4th May 2020

Re: R/62/20/HH – Erection of detached garage – Smugglers, 4 Botany Close, Rustington

Proposed Elevations
1:100

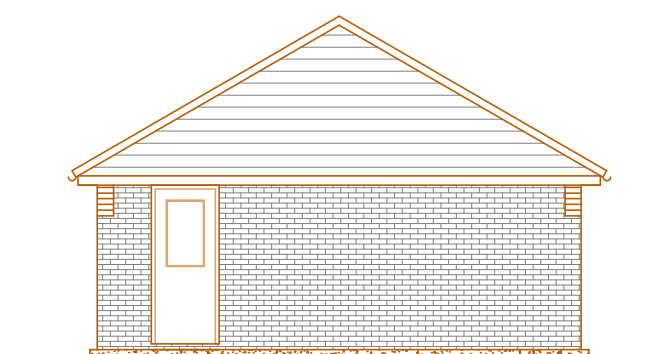
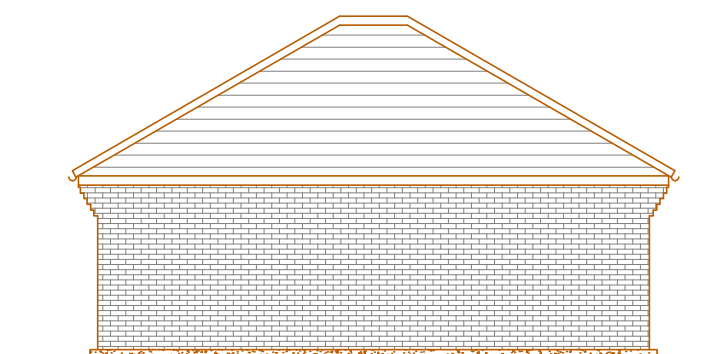
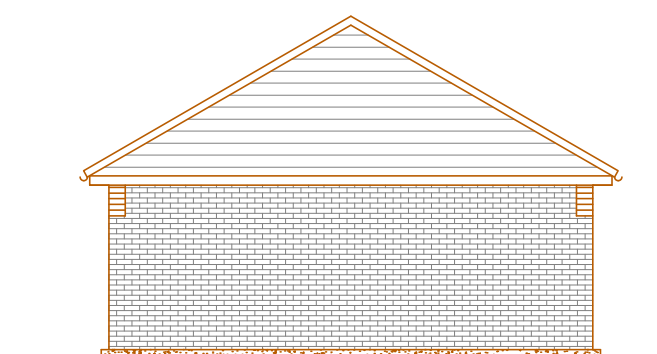
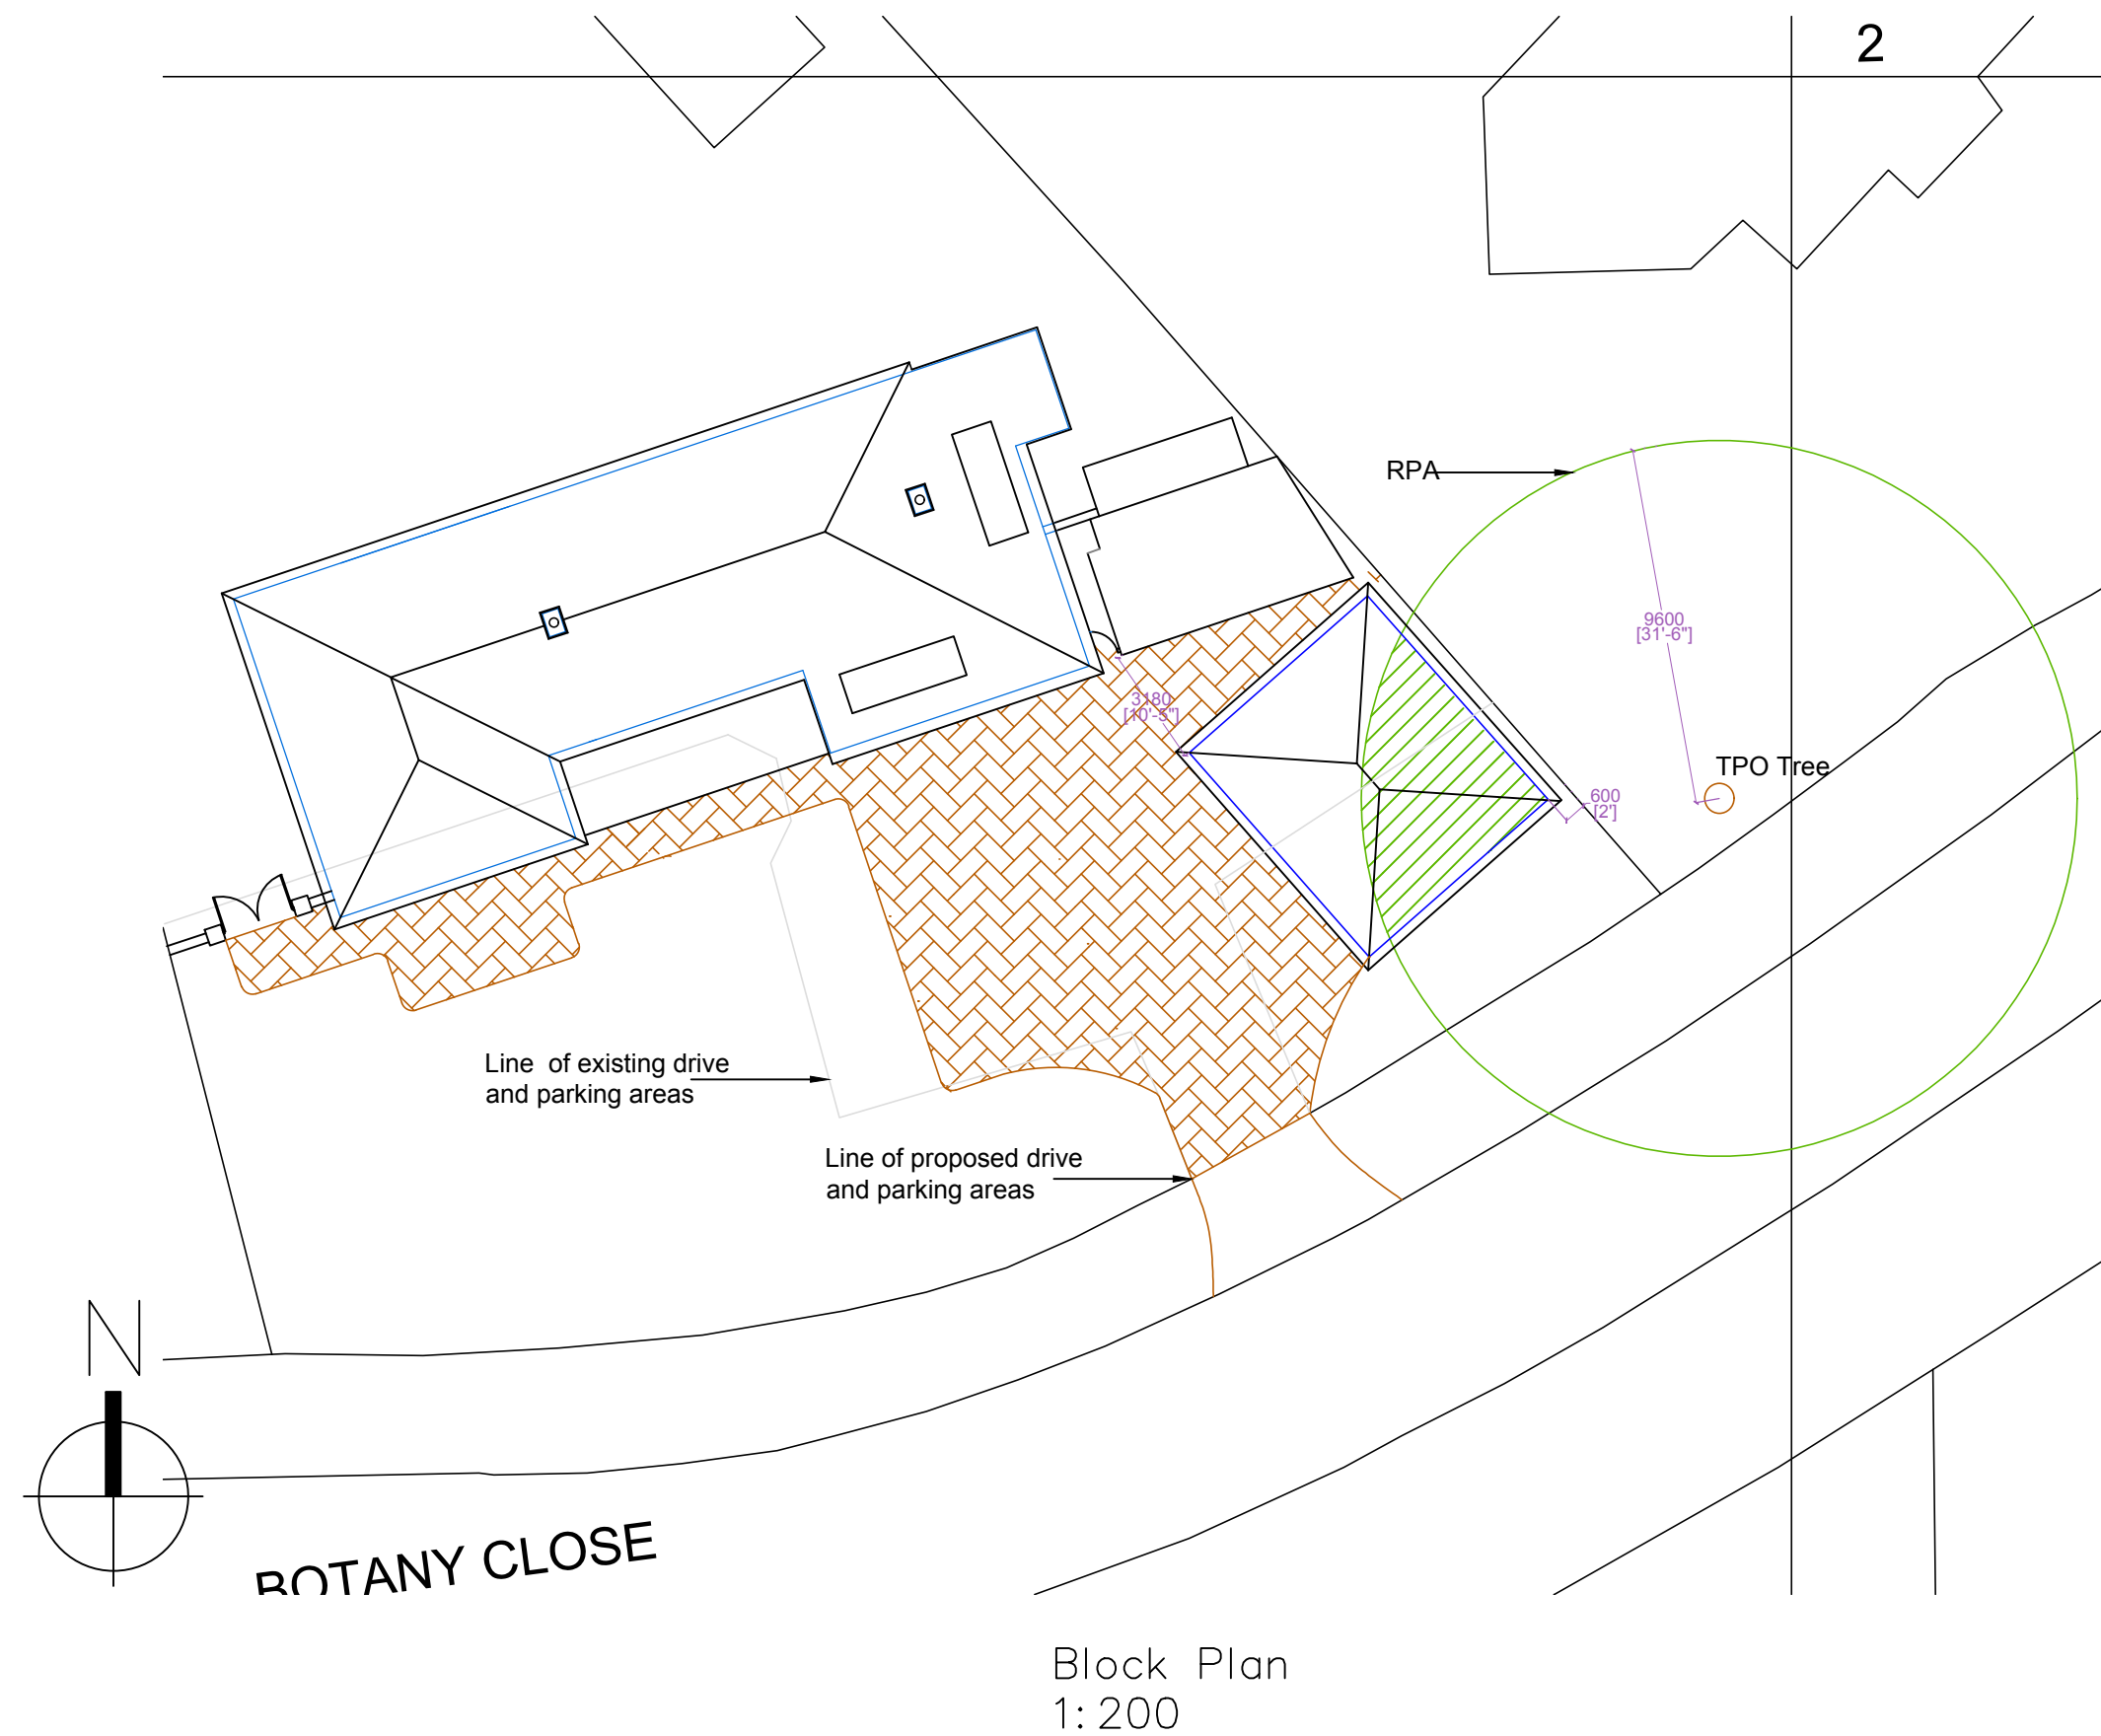
We have looked at the plans for the double garage and are worried about this structure even more so. The height of the pitched roof will be much higher than our fence and our understanding is that it will be right along our fence.

The planned garage is also not only in front of the line of the neighbour's house, but also in front of the line of our house, which surprised us, again changing the street scene and with the way it is presented on the boundary, it almost feels that we should need planning permission ourselves!

In summary, we feel that the visual impact and height of this structure, along with its proximity to our border will spoil our views and feel of our house as it is.
